# V1Site Development Plan.pdf Markup Summary

SITE PLAN

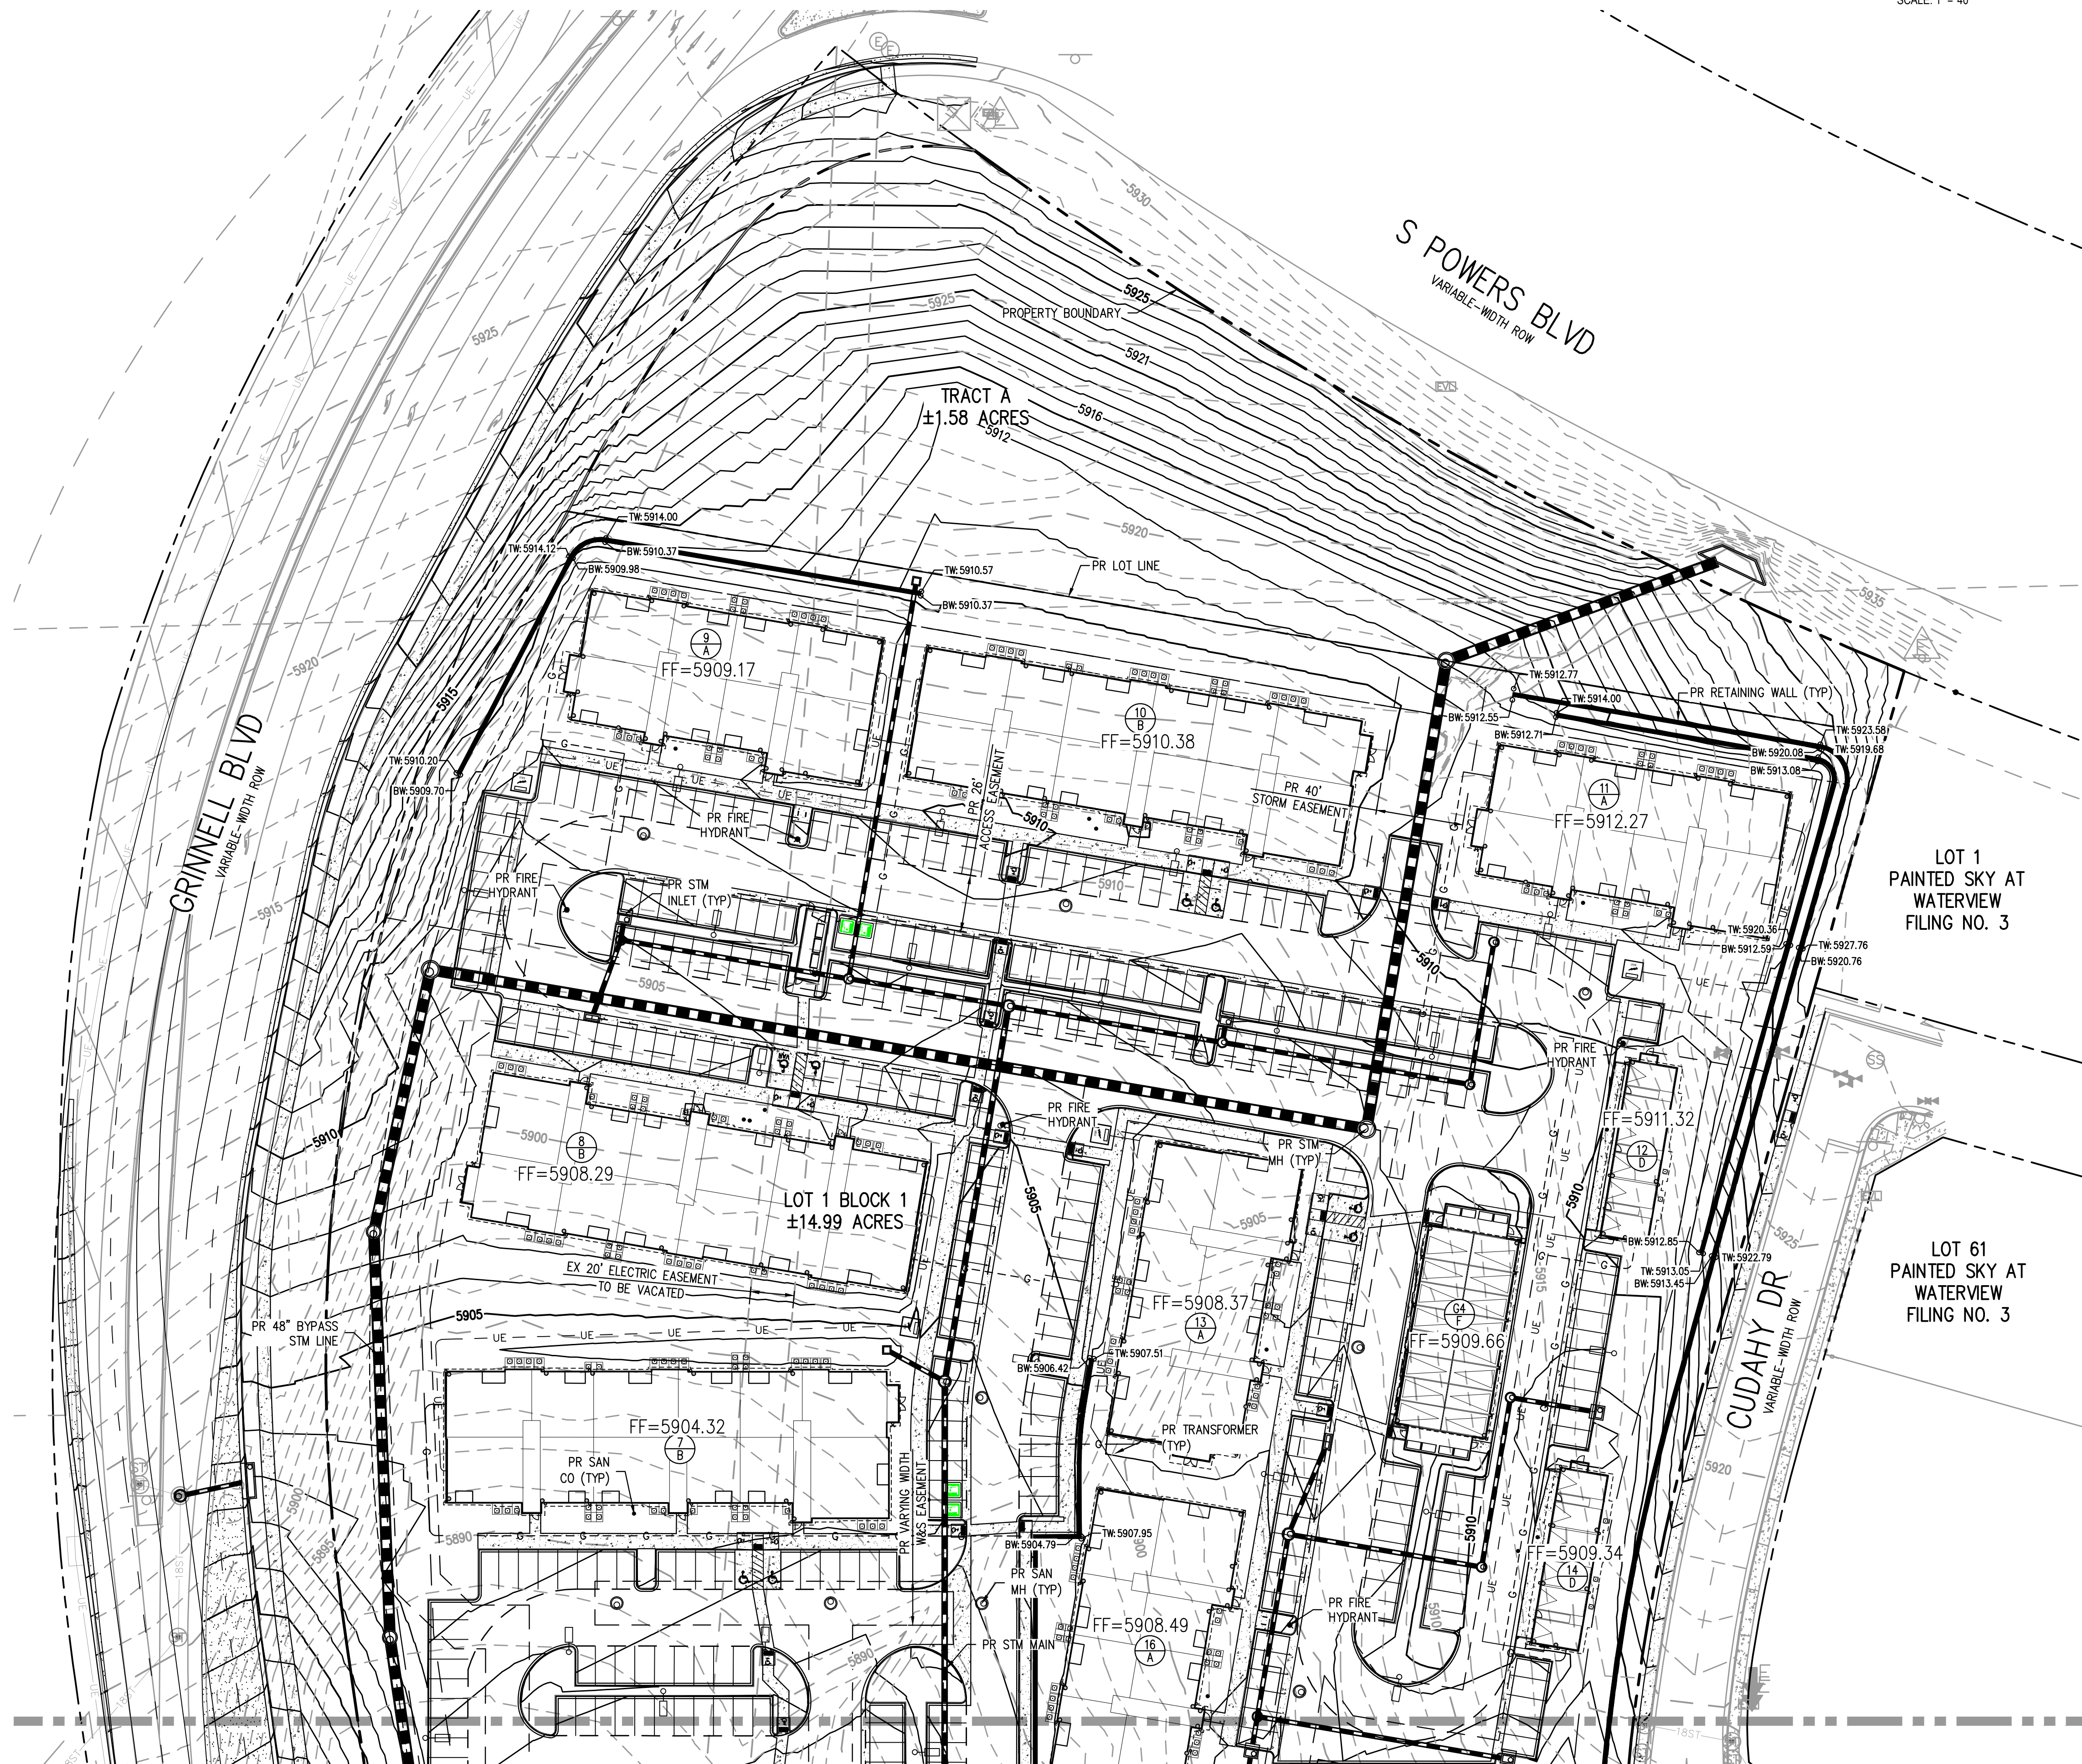
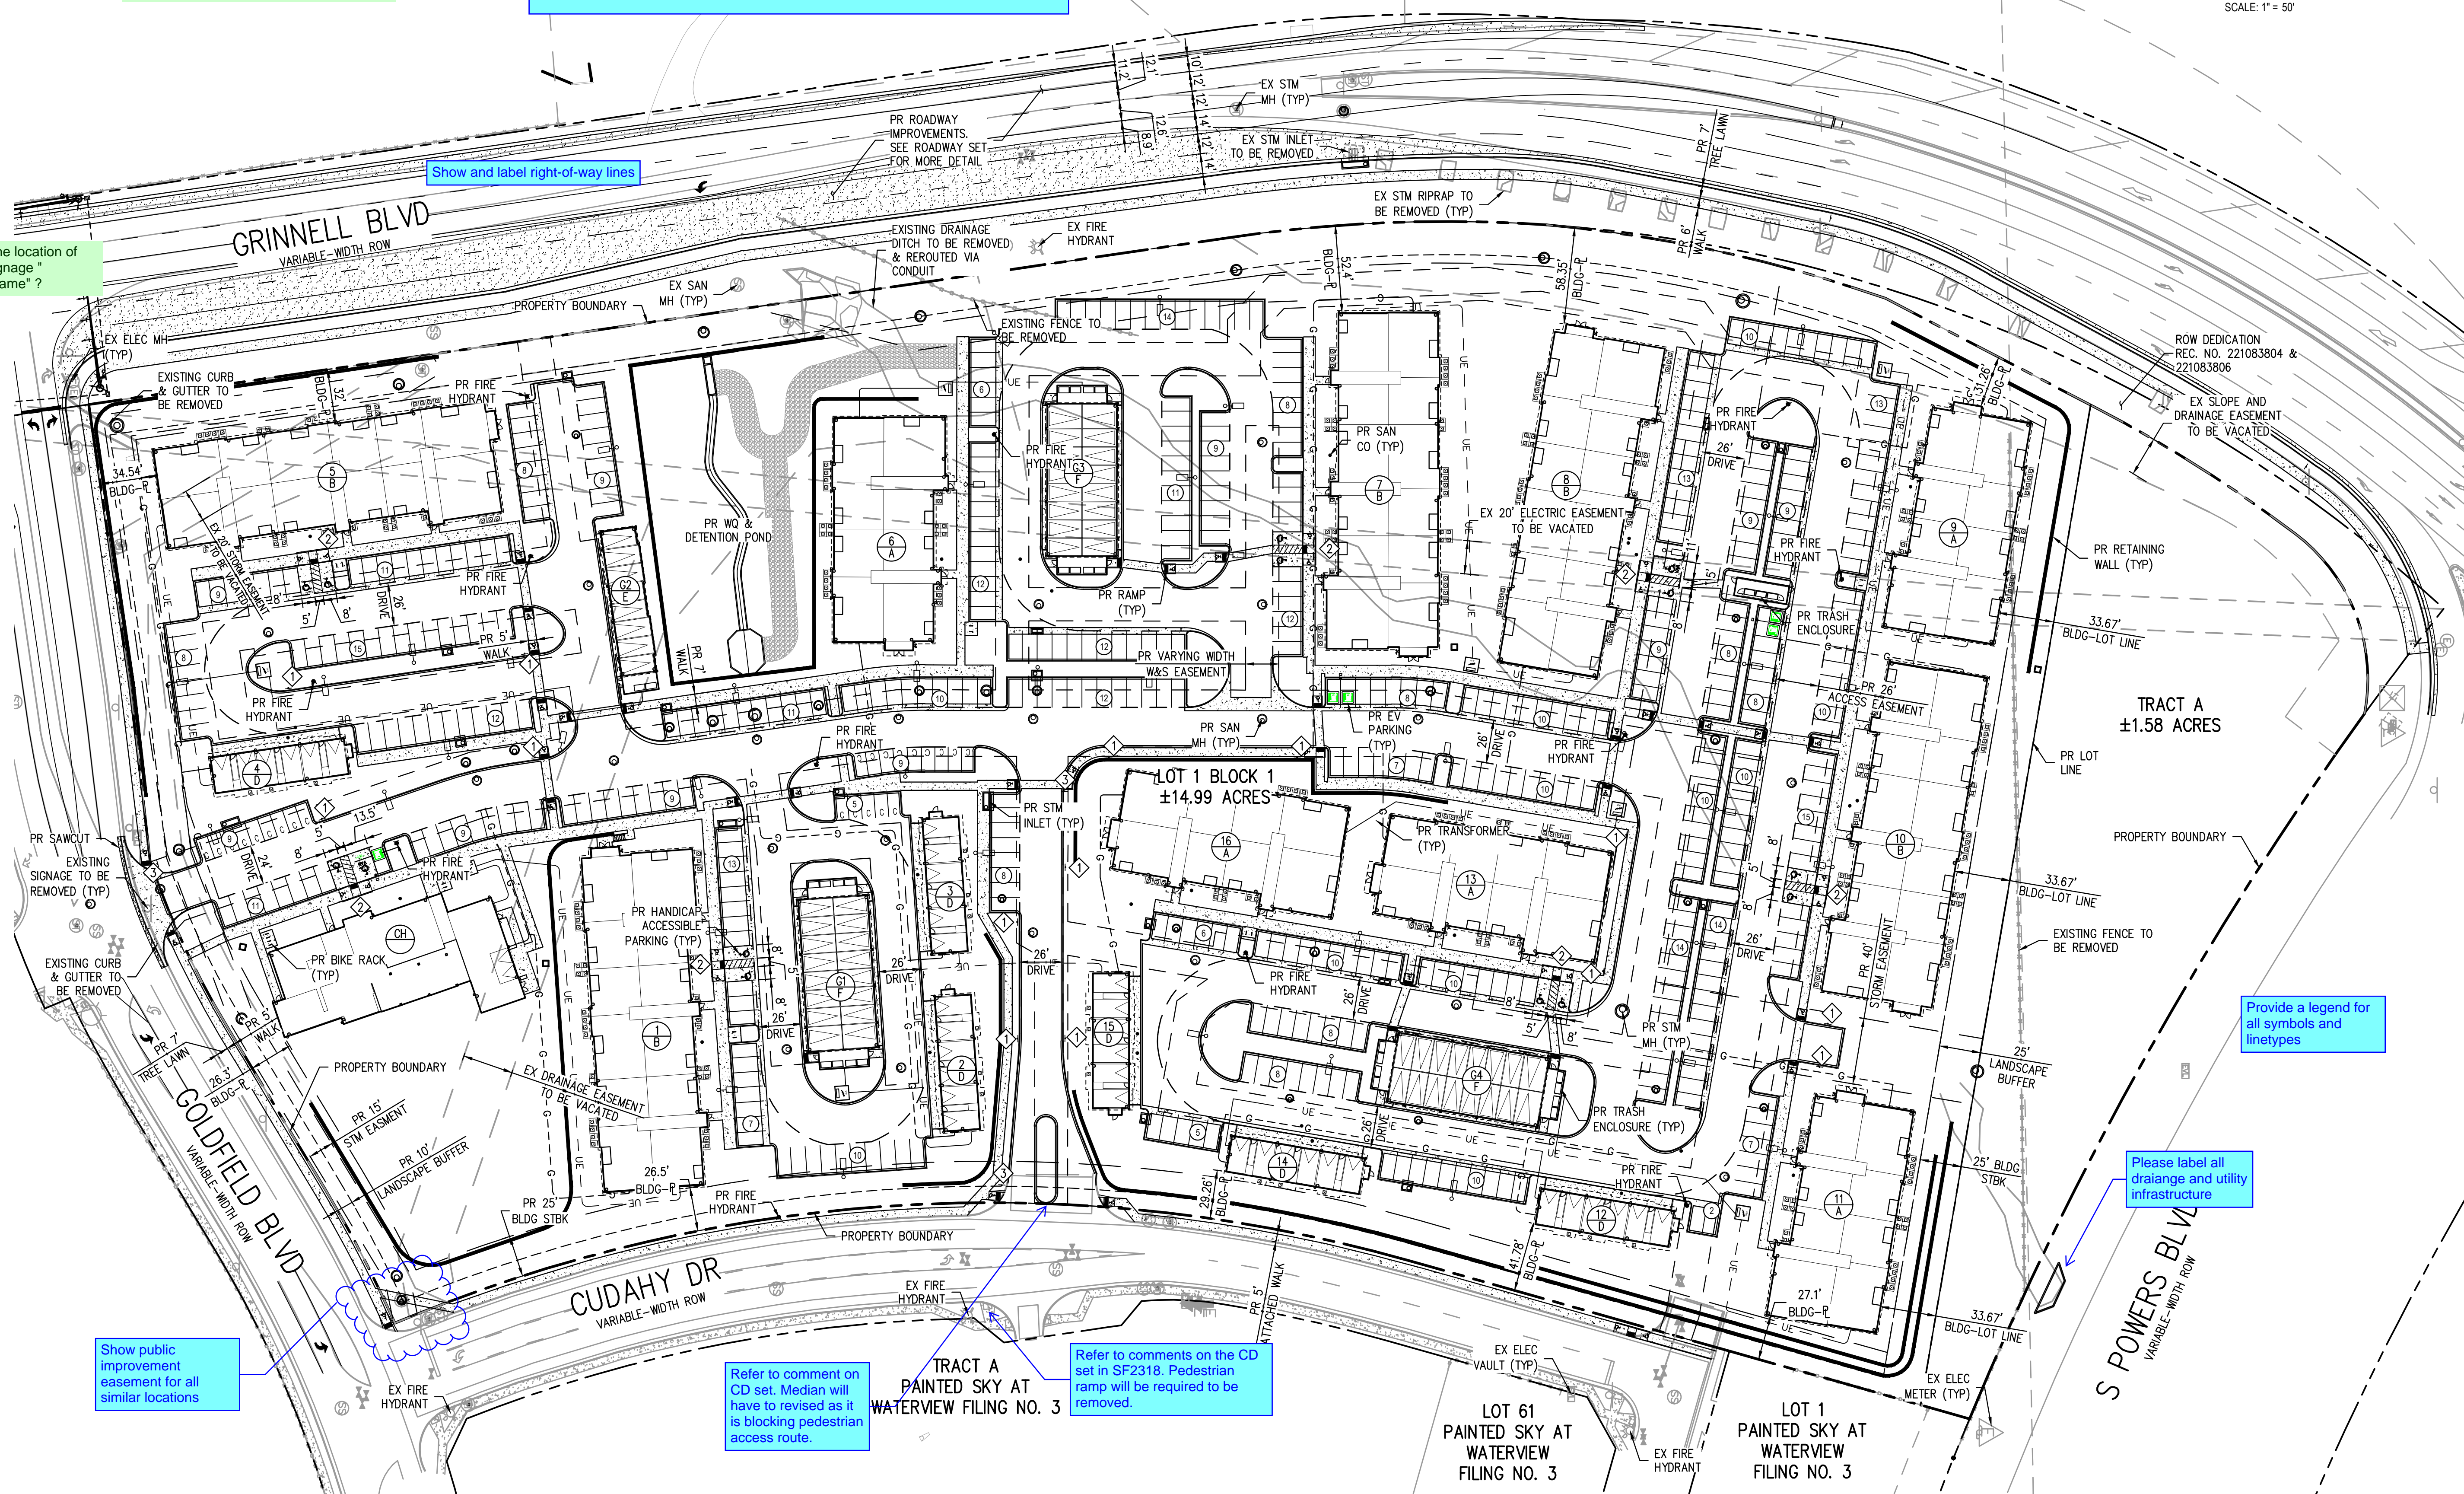
Provide a legend for all symbols and linetypes

Refer to comments on the CD set in SF2318. Pedestrian ramp will be required to be removed.

Refer to comment on CD set. Median will have to be revised as it is blocking pedestrian access route.

Please label all drainage and utility infrastructure

Show public improvement easement for all similar locations

You need to provide a legend on each page of the Site development plan .  
 That needs to include all of the symbology depicted in the images provided with this application .

Where is the location of the new signage "Property Name" ?

Refer to comments on the construction drawings in SF2318. Update site development plan to reflect revisions and comments shown on the CD set.

Show and label right-of-way lines

GRADING PLAN

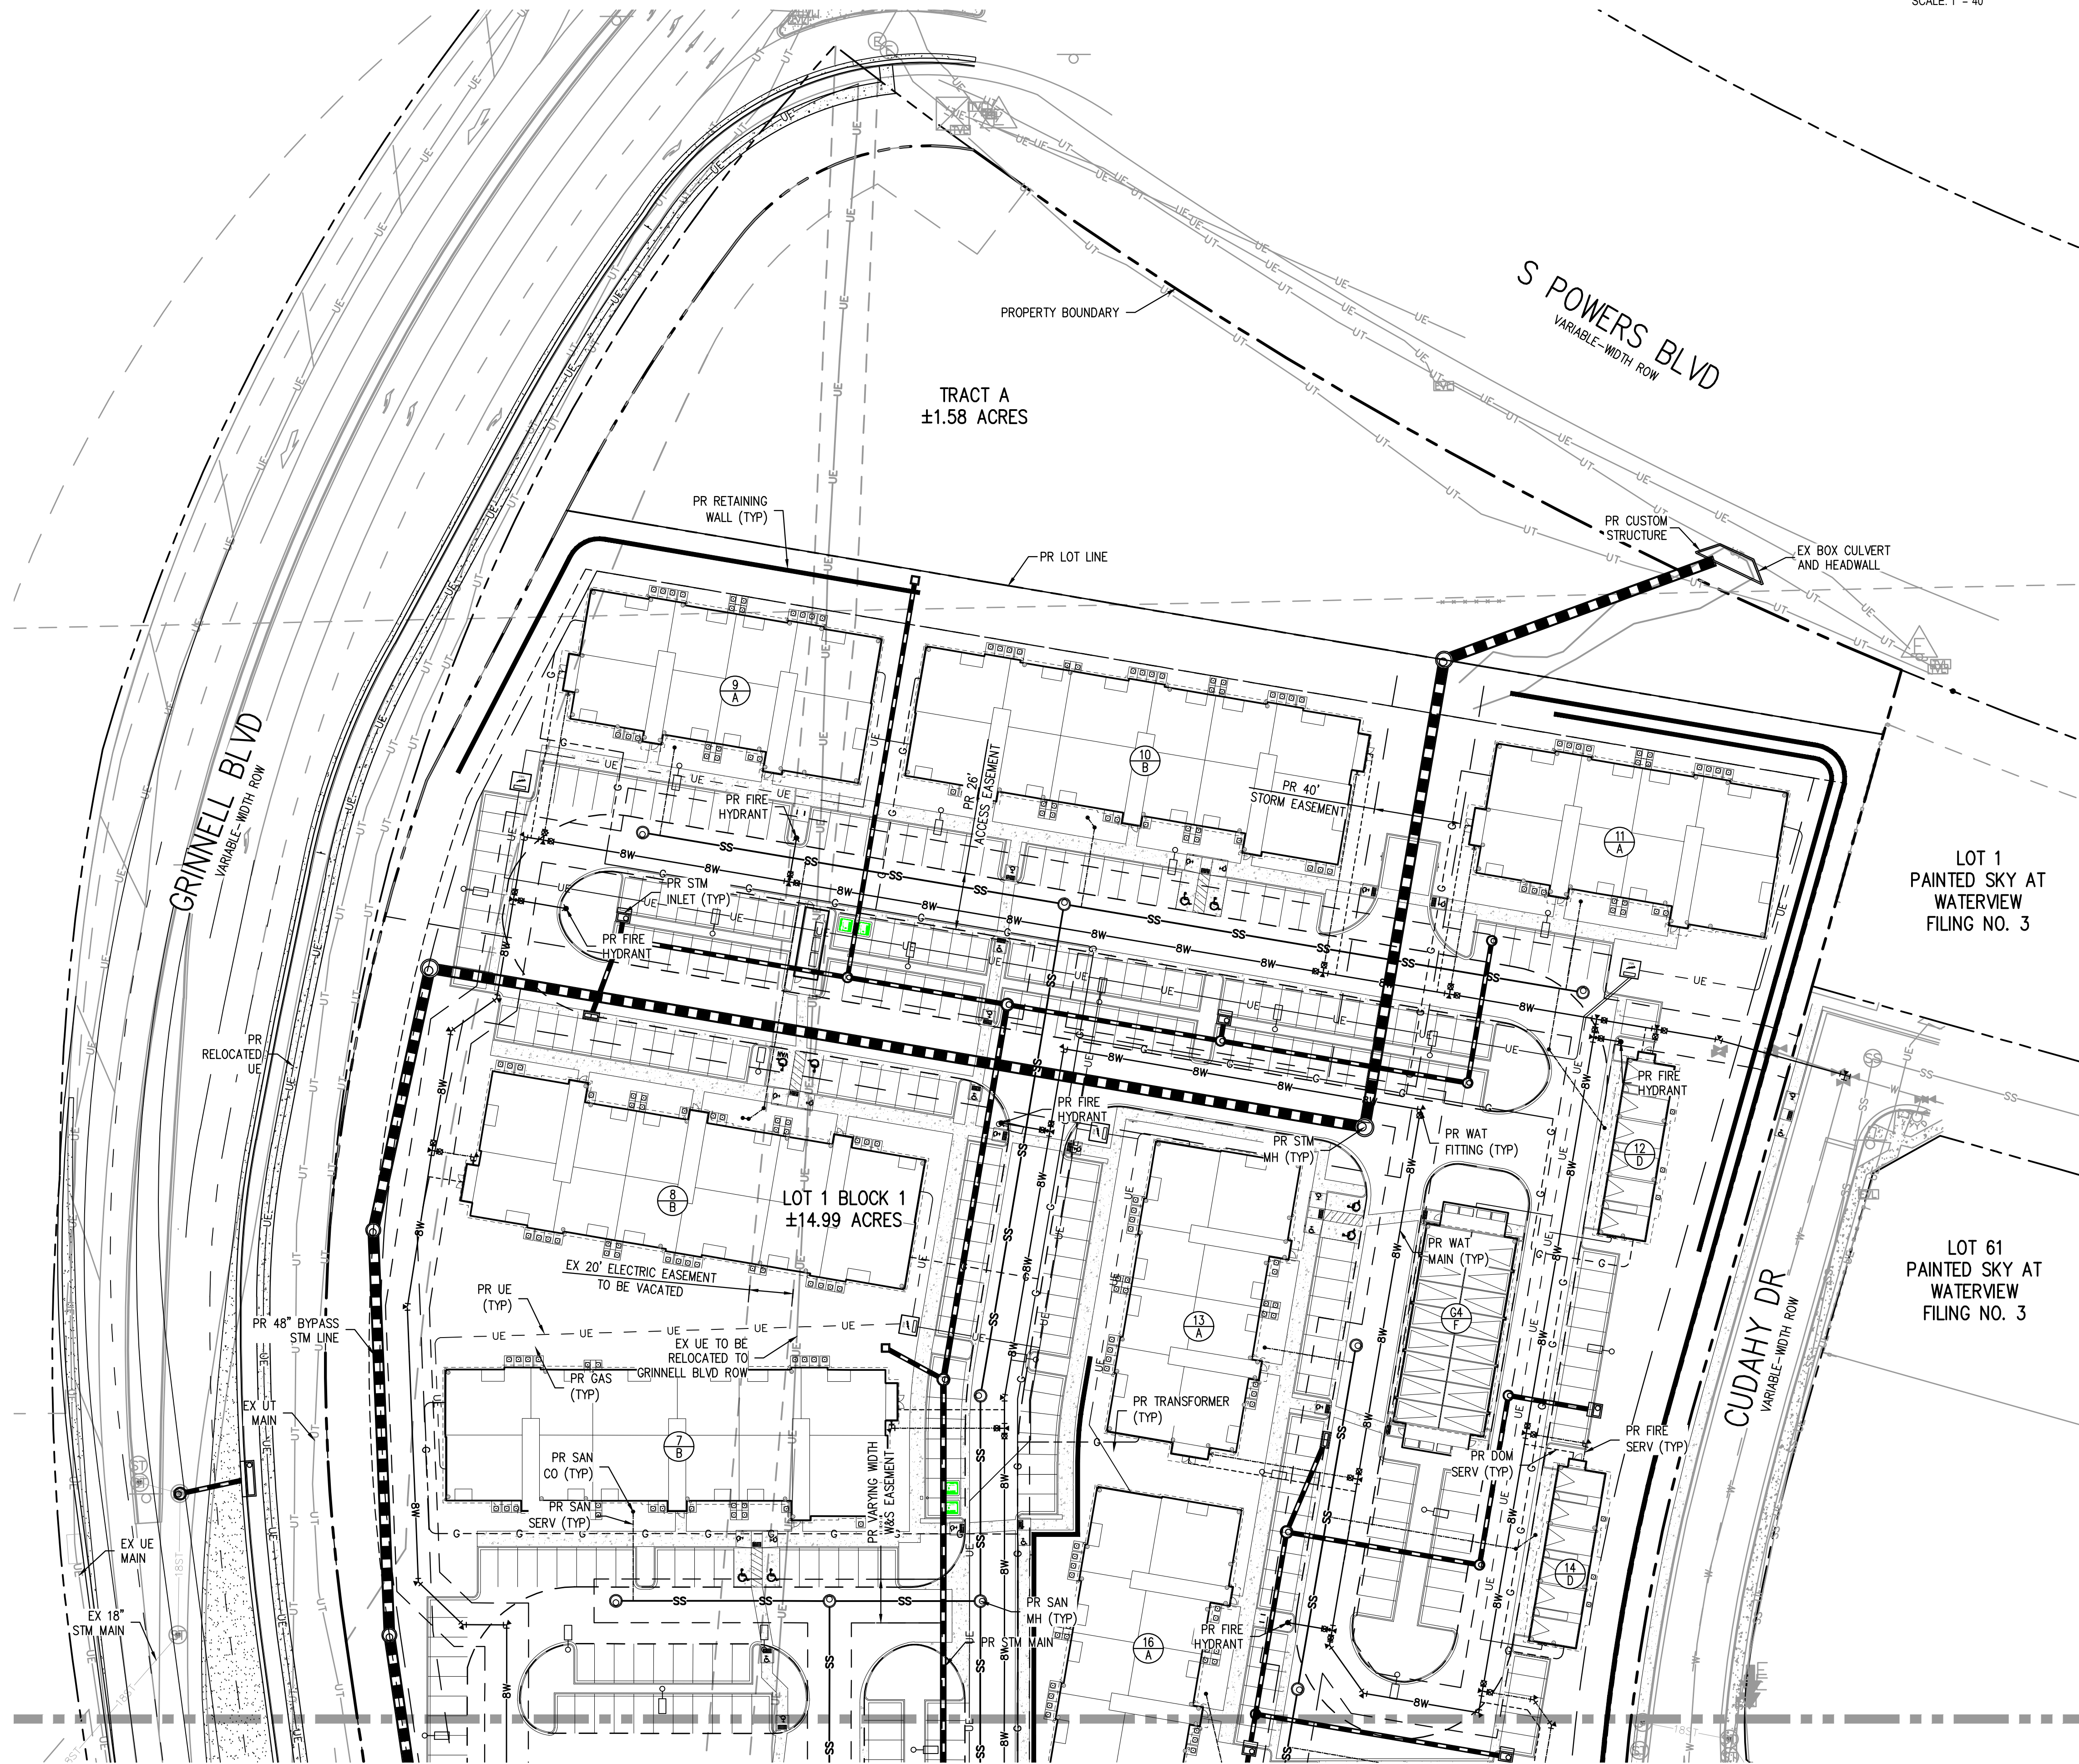
Show crossspan

See comments on CD set in SF2318 in regards to grading for sidewalks and retaining walls.
